**Your Ref:** OWPC4764  
**Our Ref:** AW/353/14/PL 18-12-2014  
**Please ask for:**  
Mr S Davis

Demolition of existing & replace with 1No. detached 3 storey dwelling. New boundary enclosure to existing front car park forecourt, existing garage access & adjust position of existing street light

11 Marquis Way Bognor Regis

project:	11 Marquis Way - Aldwick		
drawing title:	Existing and Proposed Parking Plans		
drawing status:	Planning Application		
date:	09 - 12 - 2014	scale at relevant drawing size	1 : 100 (A1) or 1 : 200 (A3)
no:	JW131105 - PL16	rev:	-

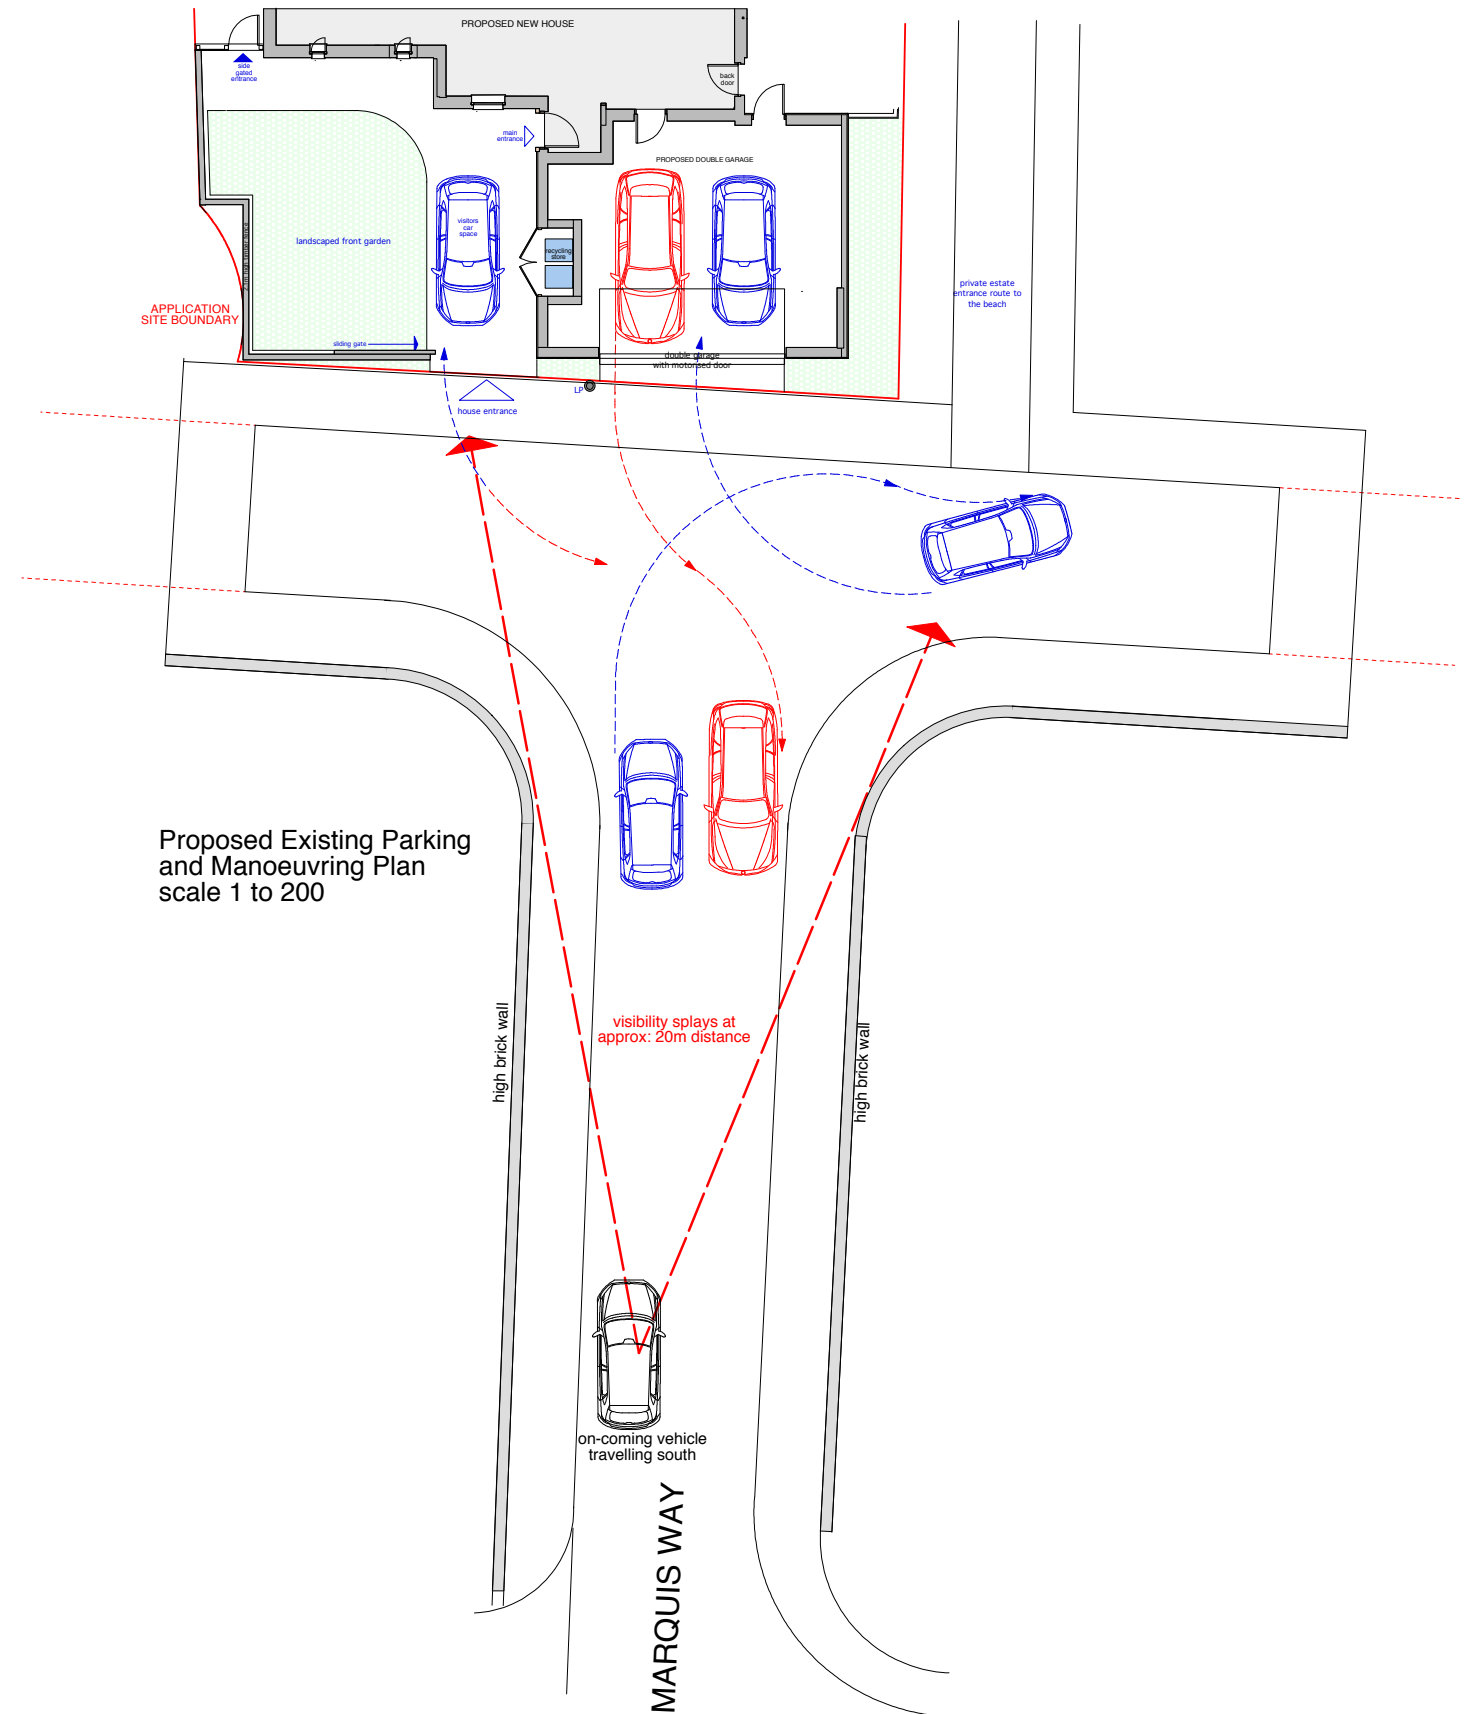
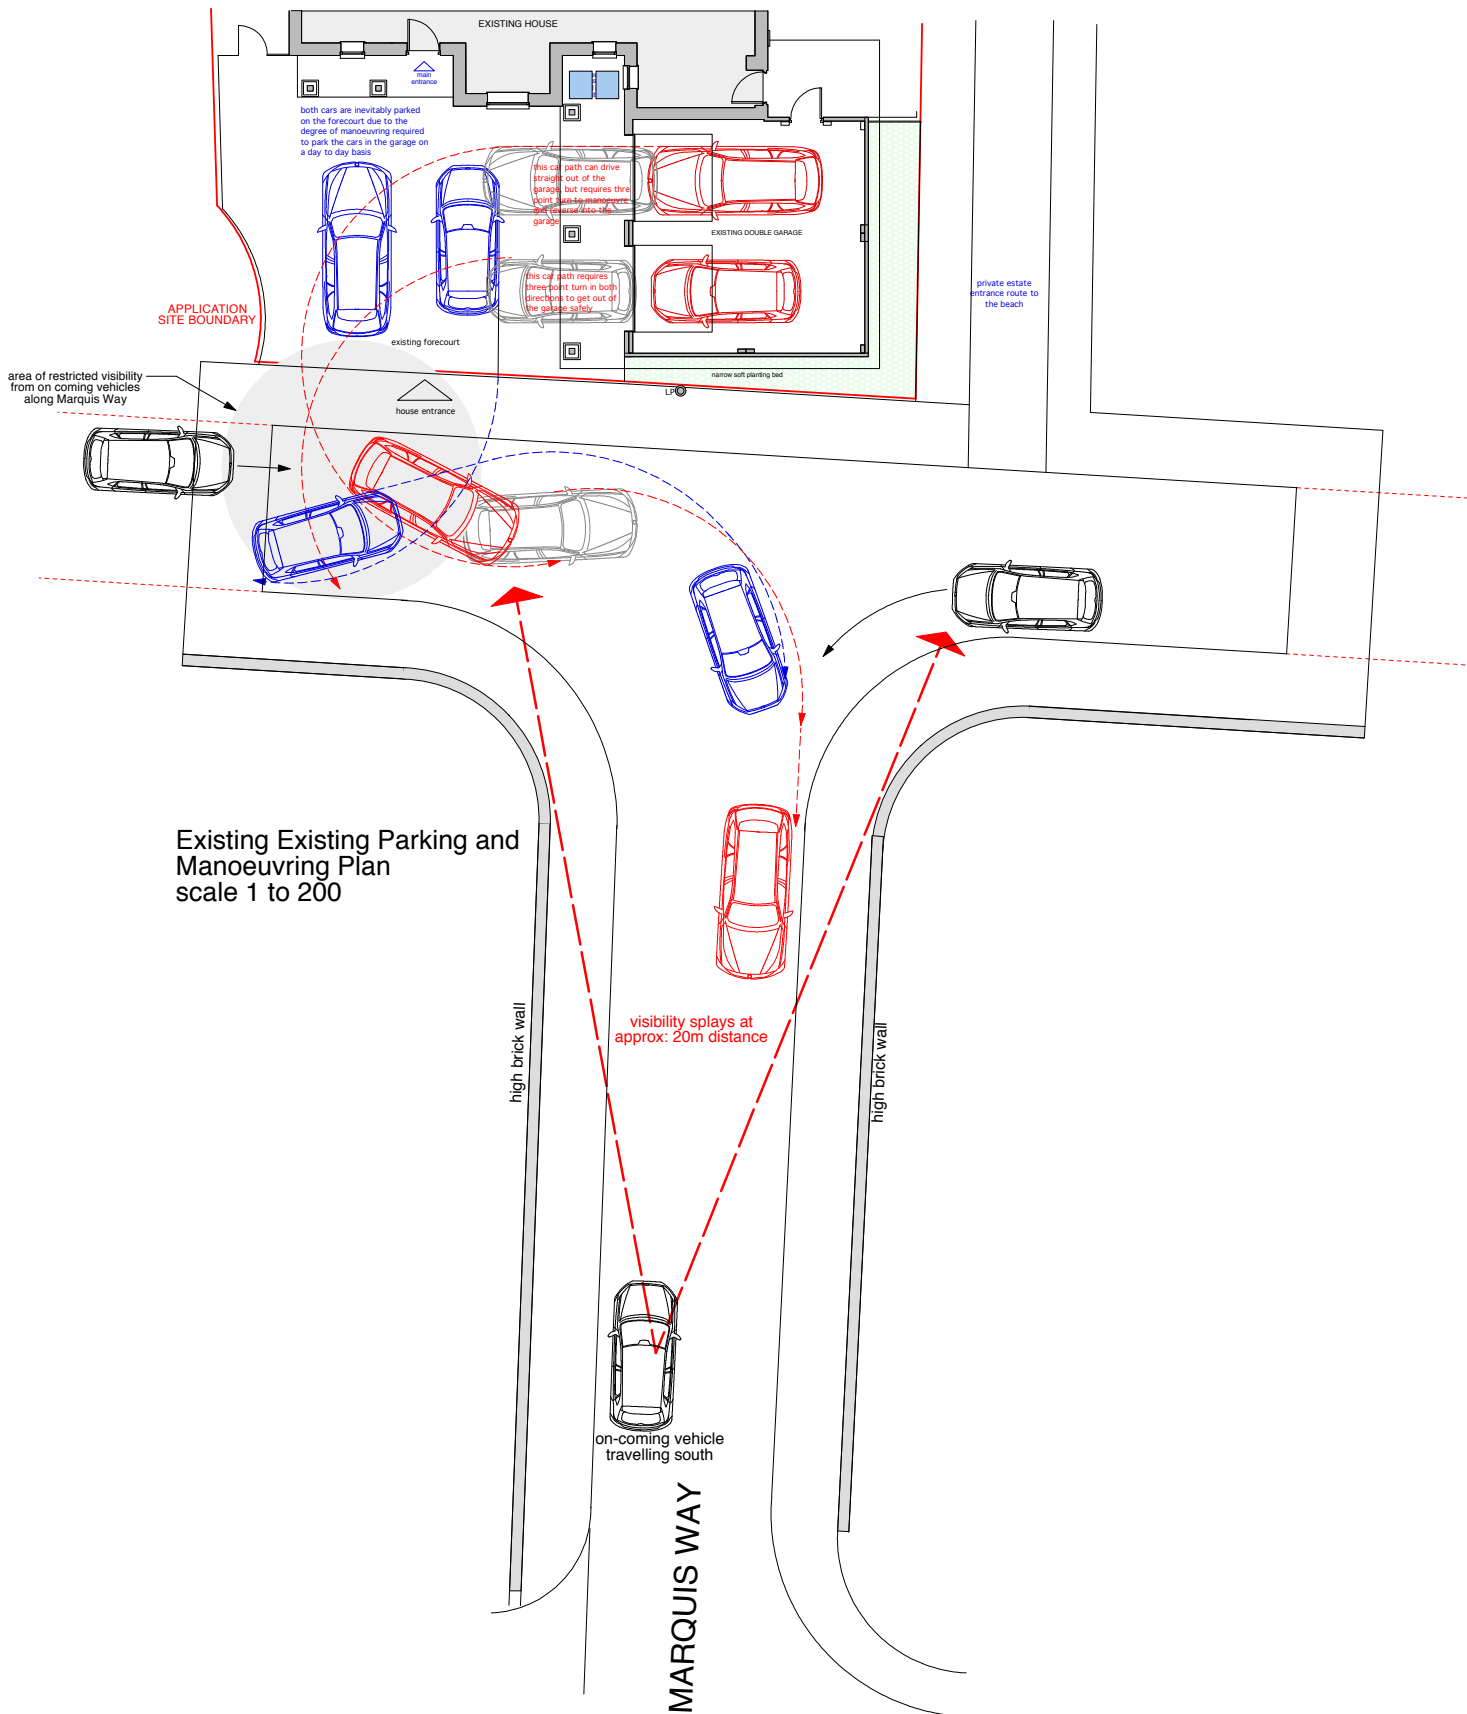
- 5. Highway safety: At the moment all the beachfront houses have garages opening onto private drives. The proposed design opens directly onto the road and will entail cars either turning around and reversing into the garage or reversing out. Both are less safe than the existing arrangement and as a parent of a 12 year old child who frequently walks past No. 11, I believe that the proposed design is unsatisfactory and potentially unsafe.*

project:	11 Marquis Way - Aldwick		
drawing title:	Proposed Sections A and B		
drawing status:	Planning Application		
date:	scale at relevant drawing size	no:	rev:
09 - 12 - 2014	1 : 50 (A1) or 1 : 100 (A3)	JW131105 - PL19	-

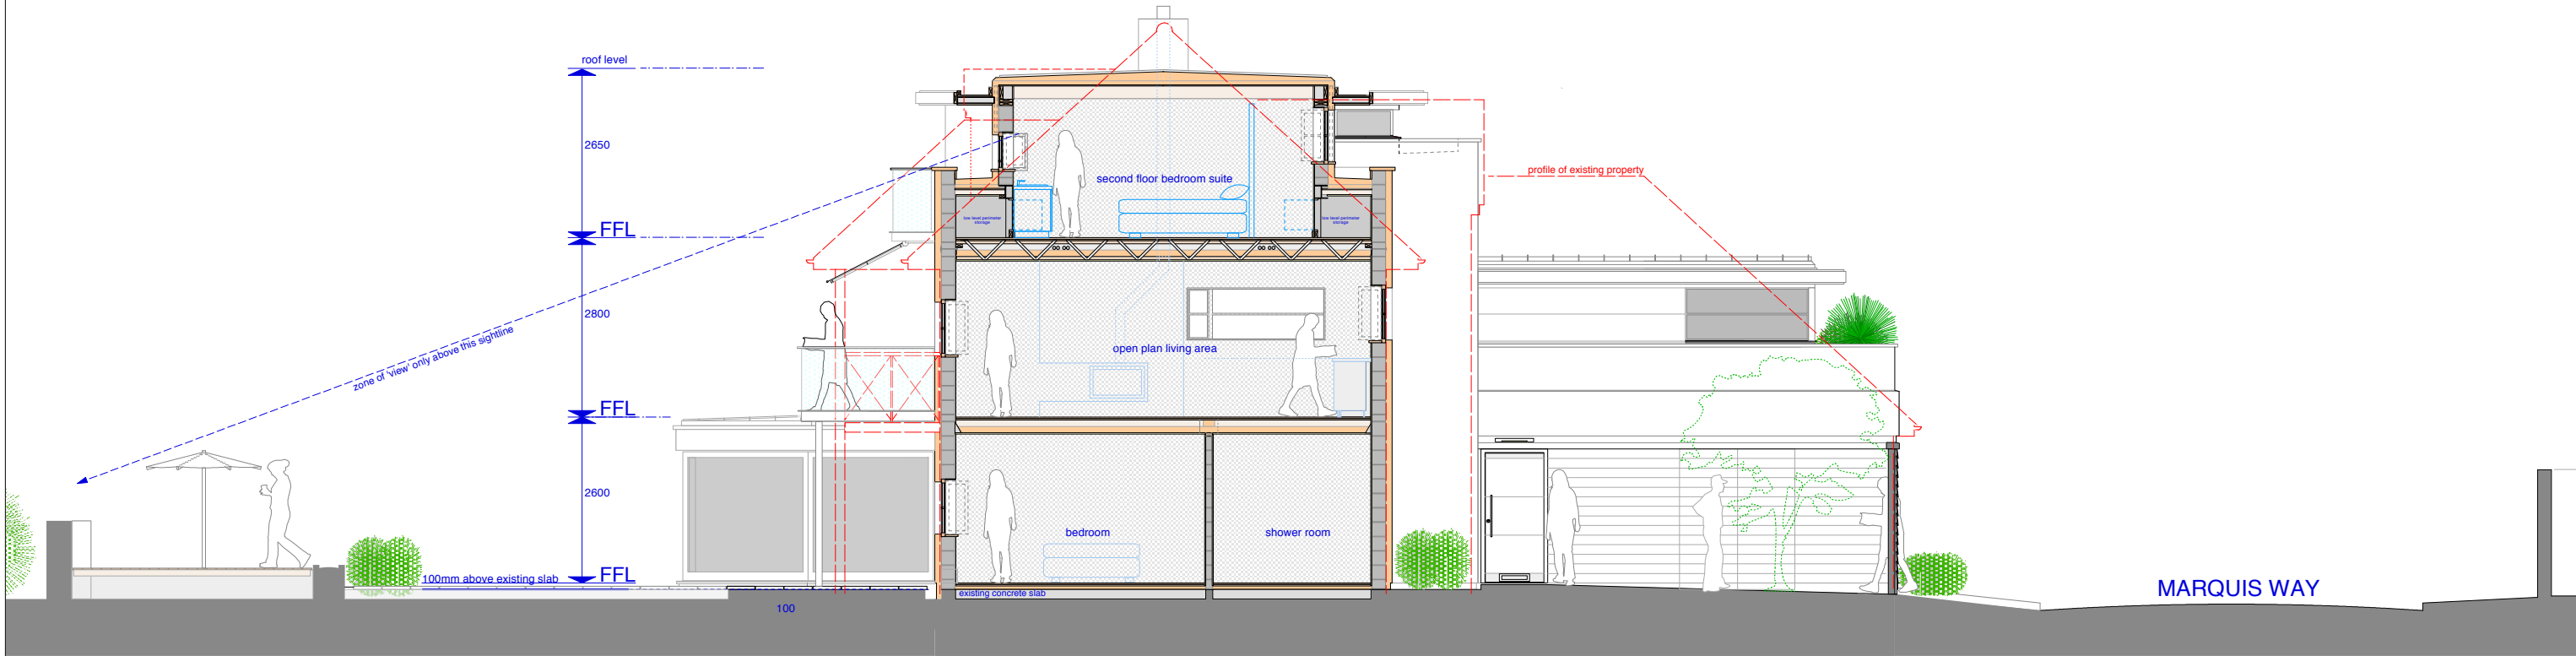
- 1. Design and appearance: All the dwellings on this estate have brick walls and tiled pitched roofs, with the six properties facing the beachfront being similar designs with alternating brick/tile colours. The proposed building is completely different from the adjacent buildings, with its flat roof and white/cream rendered finish, and would not be appropriate.*

- 3. Effect on the level of daylight: At the moment the south wall of No.11 is probably less than one metre nearer the beach than that of my own property. The existing design of No. 11 allows us to see the dawn come up - with the south-facing balcony sitting beneath two roof sections. With the proposed design, this early daylight will be blocked which I believe is unreasonable.*
